City of Mercer Island
9611 SE 36th Street
Mercer Island, WA 98040-3732

February 18, 2020

Attn: Ms. Nichole Gaudette
Senior Planner
Regarding - CAO-19-019

JOB NO. 19023.00
 DATE: 9.21.19
 SHEET: 7 OF 8
 DWG.# S1

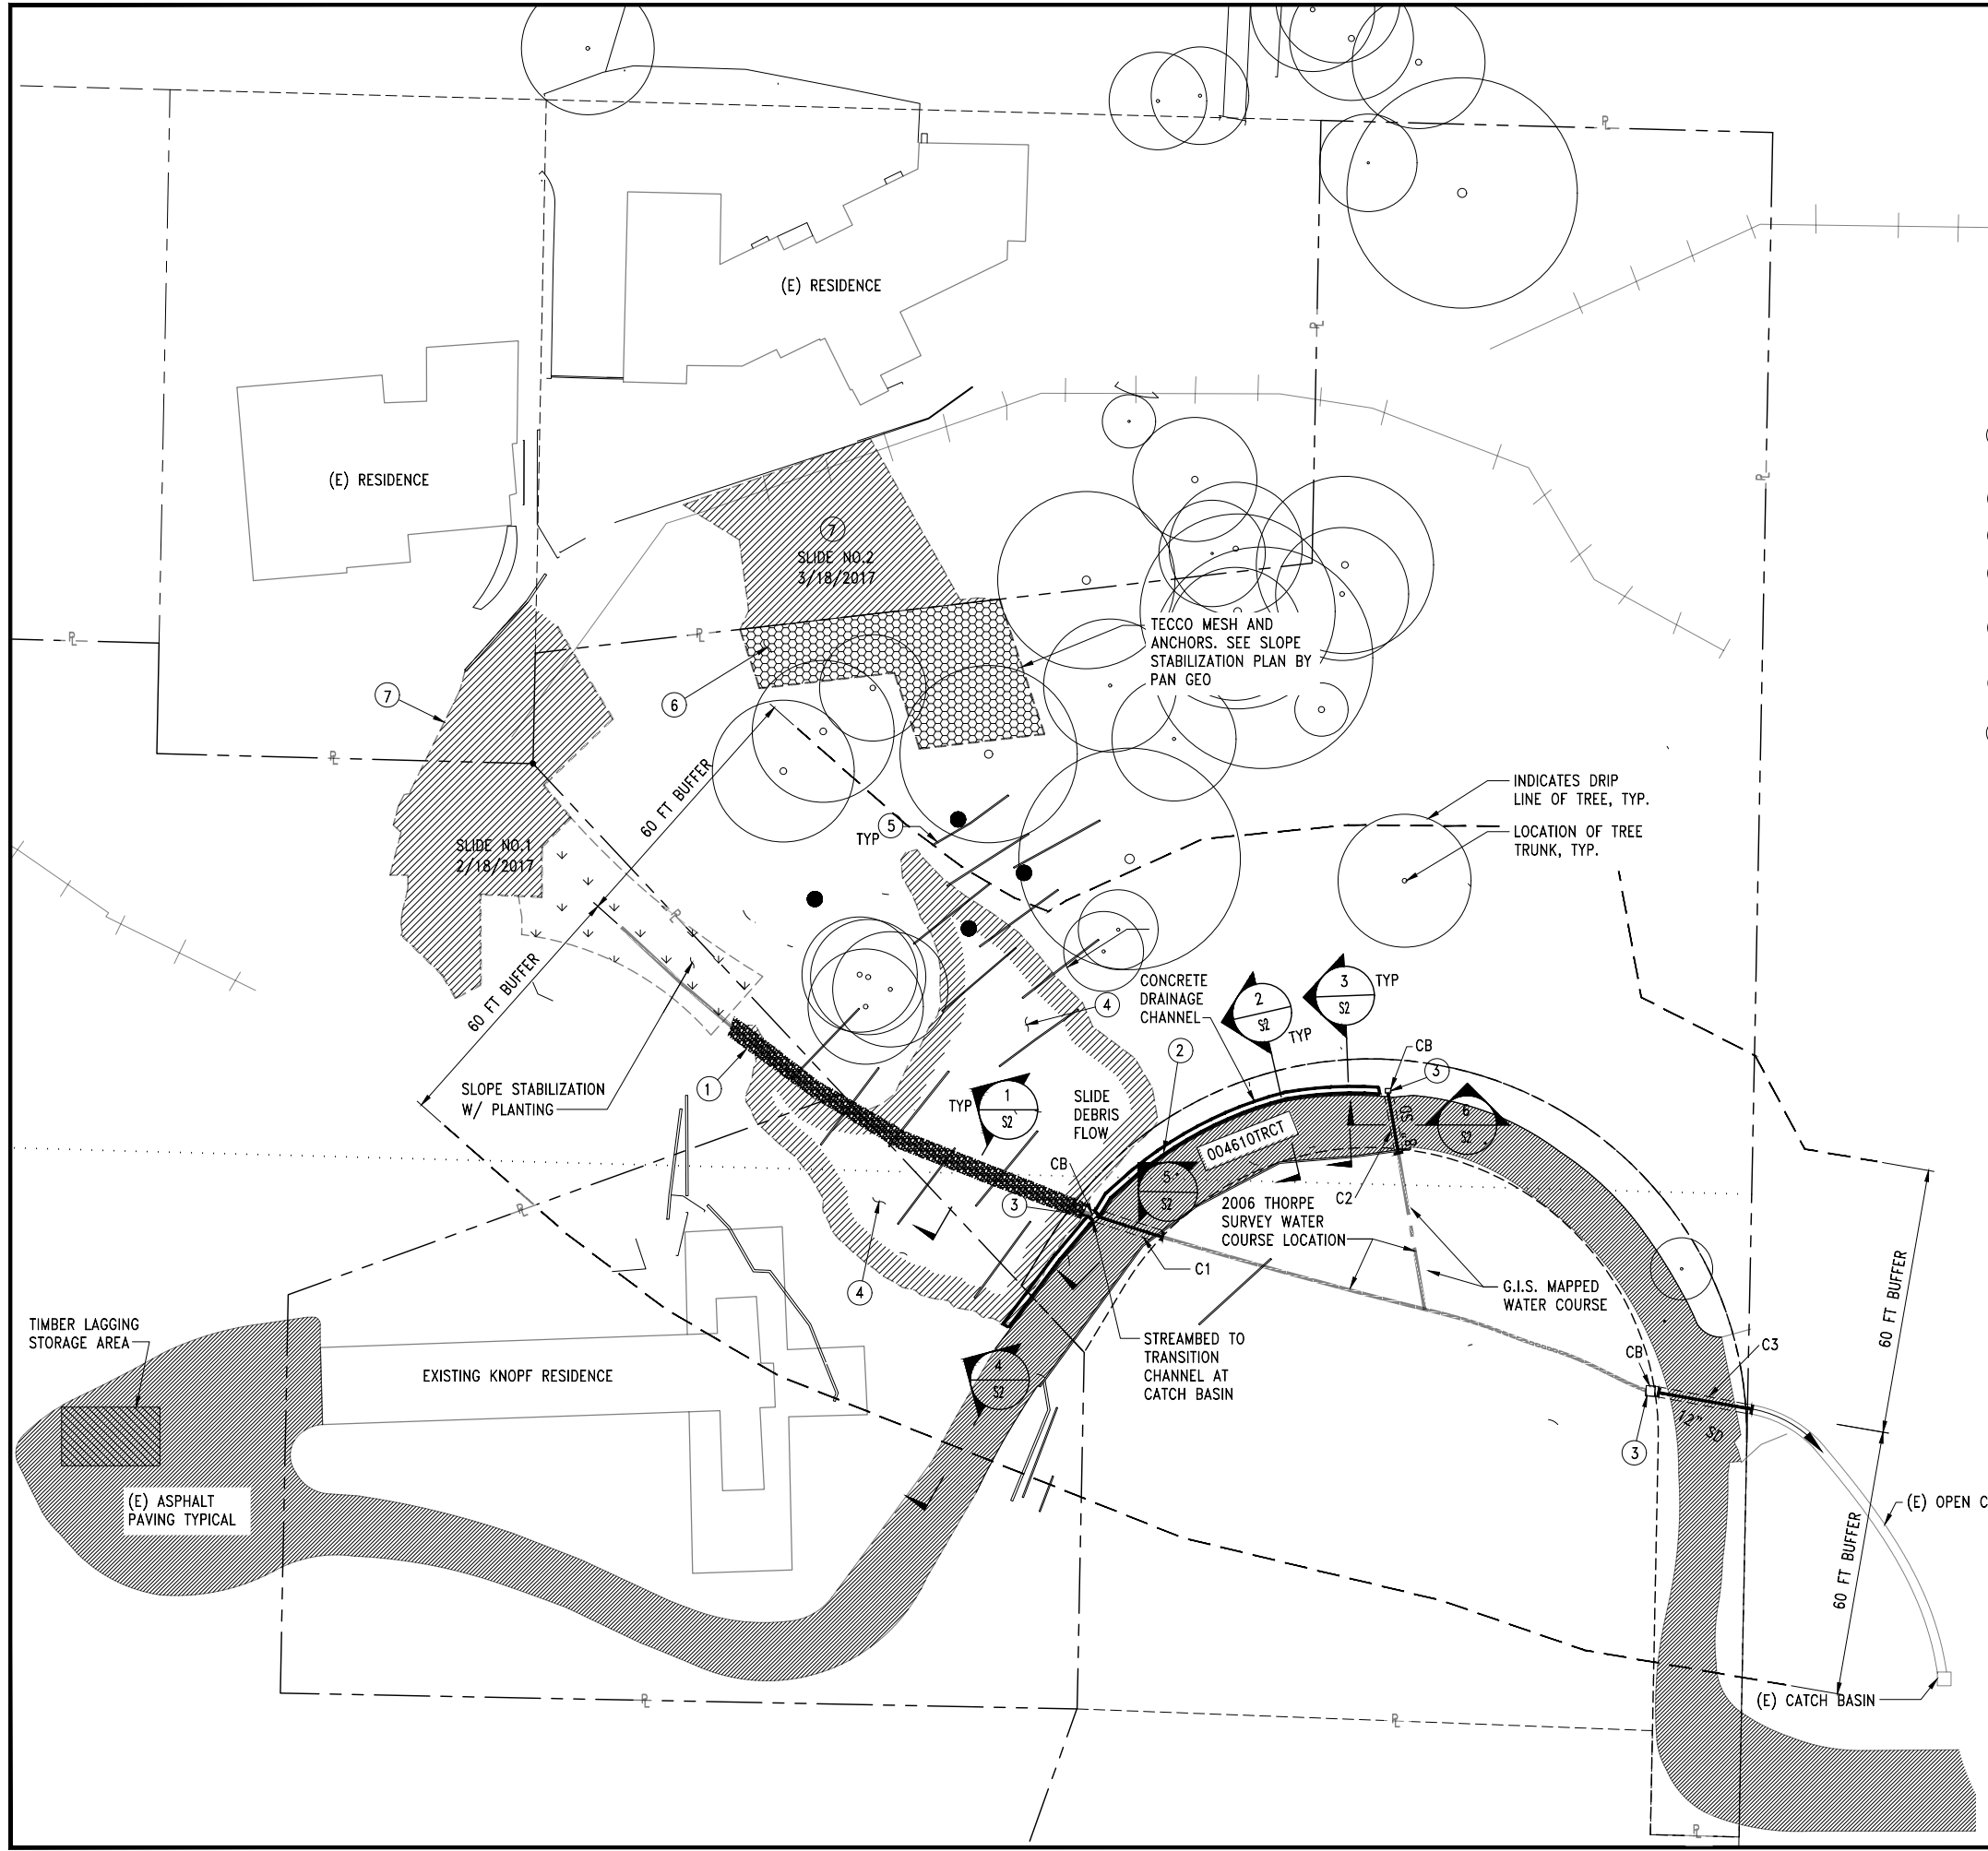
10. According to the HCE Permit Set plans, one of the proposed restoration activities includes removing the existing upper catch basin and plugging the adjoining culvert. This activity would route water flow collected from the hillside, along the uphill side of the driveway, into the lower catch basin. Currently, the upper catch basin and adjoining culvert provide water flow to an existing stream channel downslope of the driveway. This proposed activity is not considered restoration of the stream or an allowed modification per MICC 19.07.130.B. Instead, this project element would serve to divert water away from the original location of the watercourse. In addition, the HCE Permit Set plans indicate that the section of existing stream channel located downslope of the driveway will be re-aligned, but the plans do not provide any details for how this will be completed. The details regarding re-alignment of the stream are necessary for assessing the proposal's consistency with MICC Chapter 19.07. Re-aligning an existing stream channel may not be allowed by code if other alternatives with lesser impact are feasible. The removal of the upper catch basin and plugging of the adjoining culvert in the HCE Permit Set plans should be reevaluated so current water flow is not completely re-routed from the existing downslope stream channel. The HCE Permit Set should be revised to include details regarding the re-alignment of the existing downslope stream channel.

11. According to MICC 19.07.180.C, the standard buffer for a Type Np stream is 60 feet. Based on the HCE Permit Set plans a 50-foot stream buffer is proposed. Please increase the buffer to 60-feet.

We are no longer removing any catch basing or blocking culverts. The stream will continue to flow in its historical location with no diversions.

The 60 foot buffer has been updated on the drawing set.

JOB NO.	19023.00
DATE:	9.21.19
SHEET:	8 OF 8
DWG.#	S2

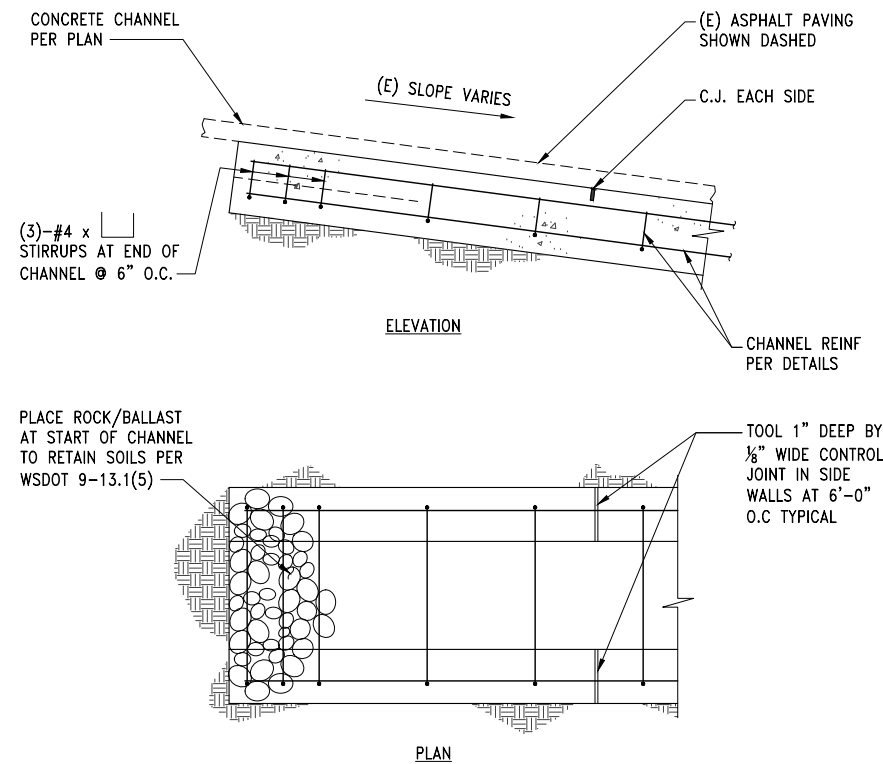
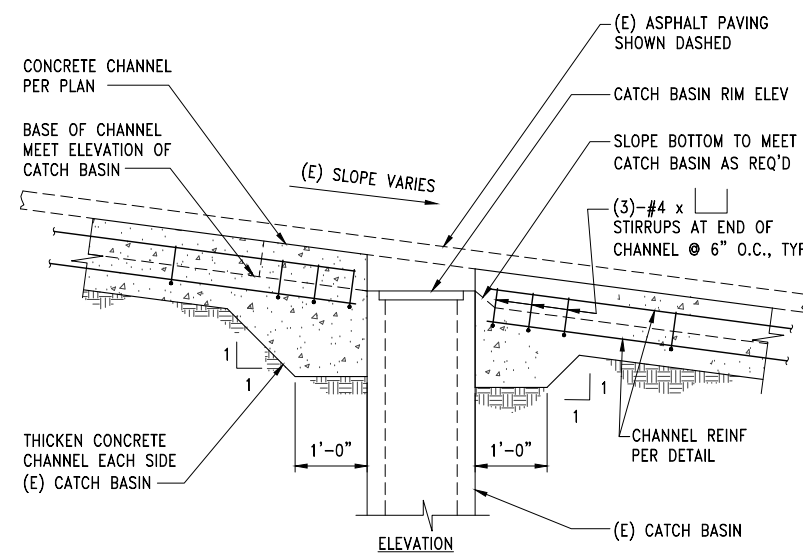
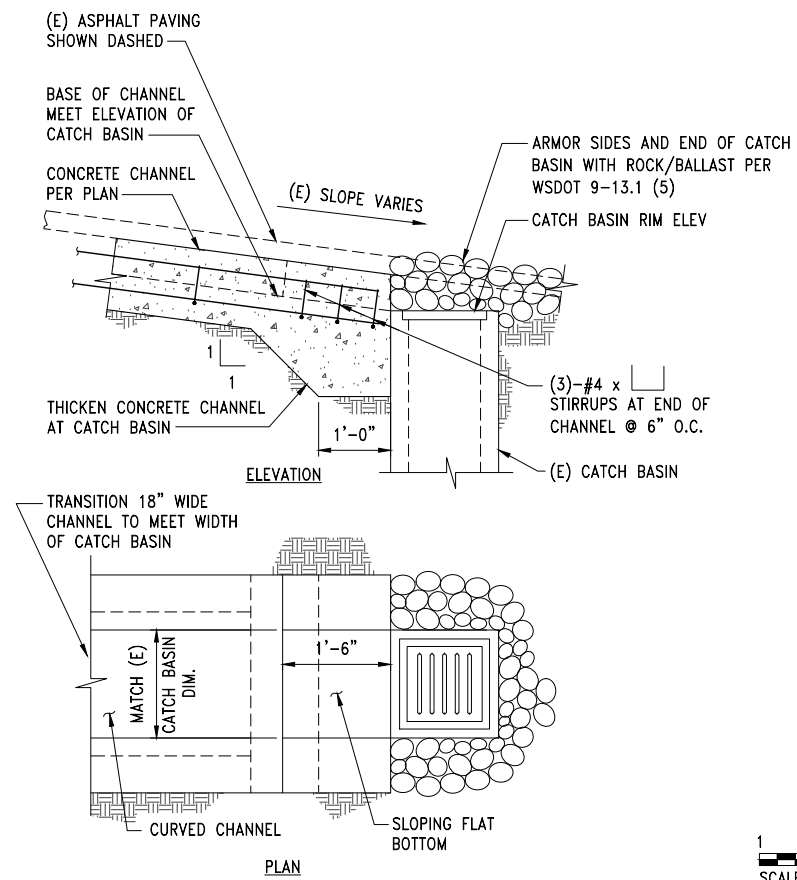
12. Based on review of the September 4, 2019 Landslide Restoration Recommendations Letter prepared by Pan Geo, Inc., the concrete-lined trench may be a viable alternative to the original proposed system as it would include fewer artificial components; however, there are two concerns associated with this alternative. First, we are concerned that a concrete lined trench could alter peak flows and potentially lead to downstream erosion and scour of the open channel. This issue should be addressed in any future proposals for the alternative. Second, barring further design details, we are concerned this alternative could include removing the upper catch basin and plugging the adjoining culvert, similar to the original proposed system. If this activity is included, we do not believe the alternative would be considered restoration of the stream and an allowed modification per MICC 19.07.130.B. Ensure that any future proposals for the concrete-lined trench consider the issues presented above.

The concrete drainage channel will be 'roughened' to slow down the flows during peak events. See detail 3 / S-2.

PLANT SCHEDULE - APPROXIMATE

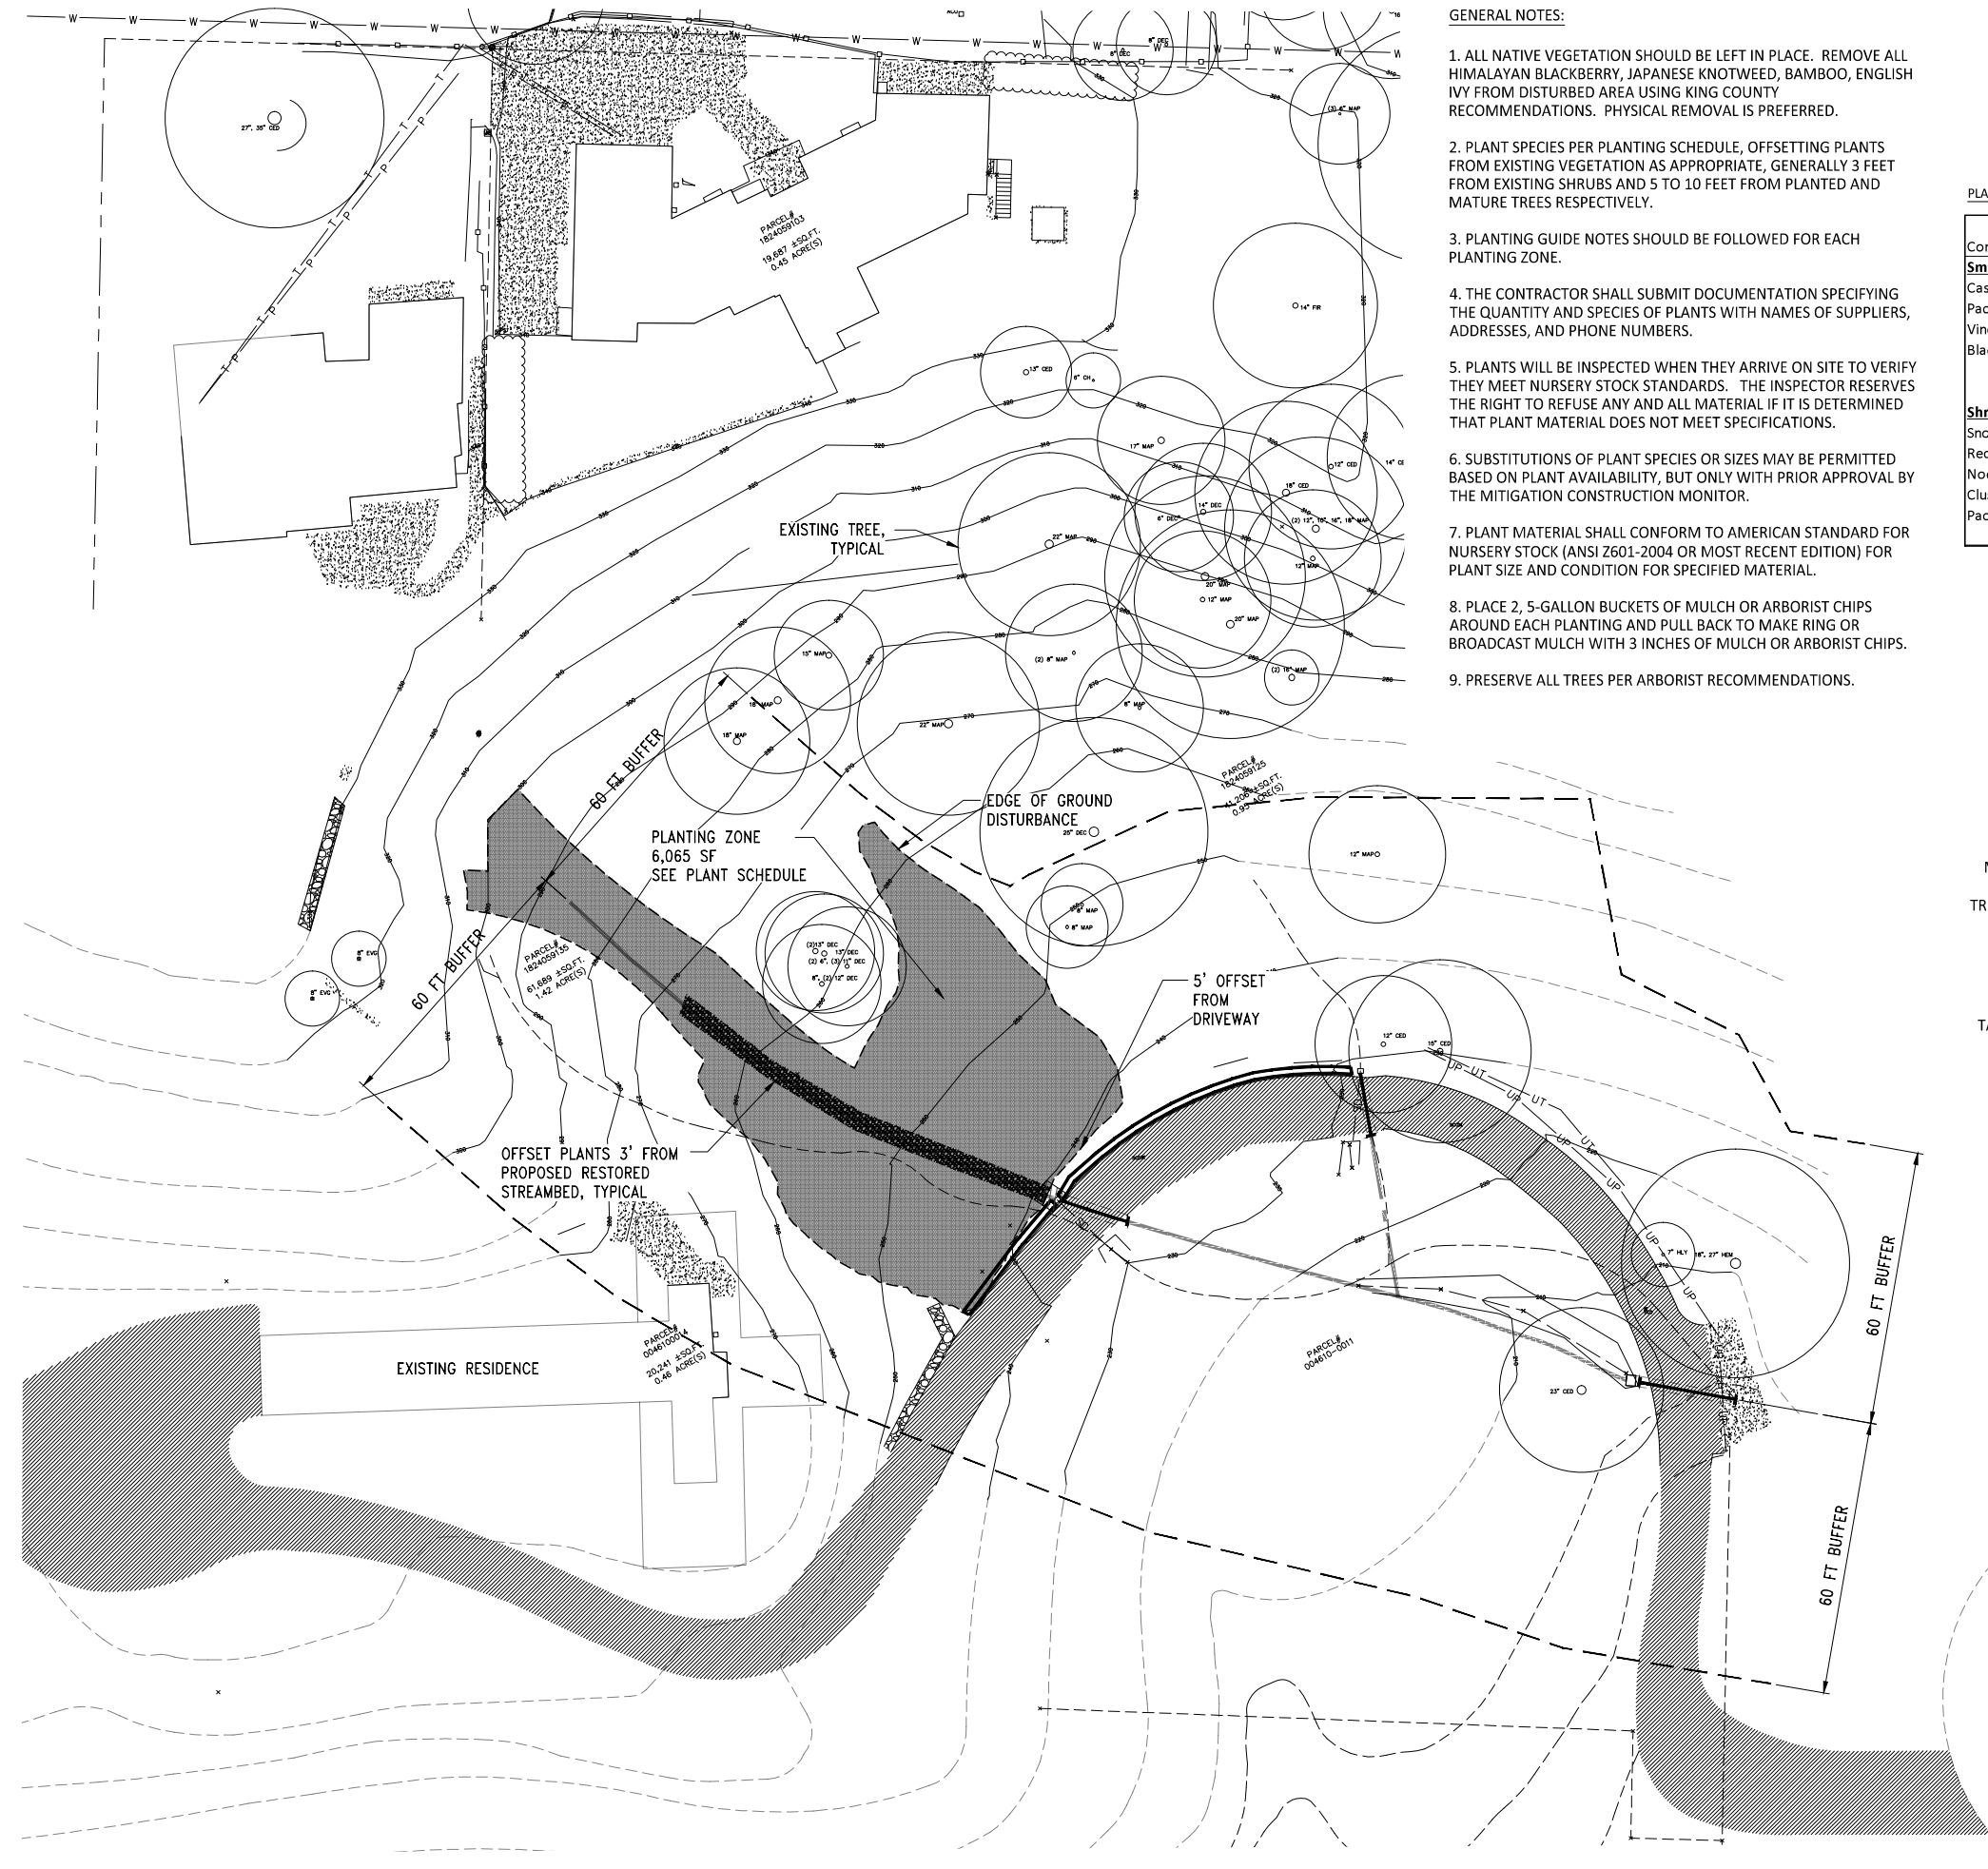
7. According to the Slope Re-Vegetation Memo and Planting Plan, many of the proposed plantings include species such as vine maple, serviceberry, snowberry, cascara, and red elderberry, which are characteristically found in drier, upland habitats. Based on our site visit, the areas proposed for planting appeared to be wet throughout the year. Please revise the proposed plant species in the Slope Re-Vegetation Memo and Planting Plan to include species that would successfully establish and improve ecological functions of the re-established stream. Recommended species could include salmonberry, Pacific ninebark, peafruit rose, red-osier dogwood and/or willow.

See attached for revised planting memo and plan.
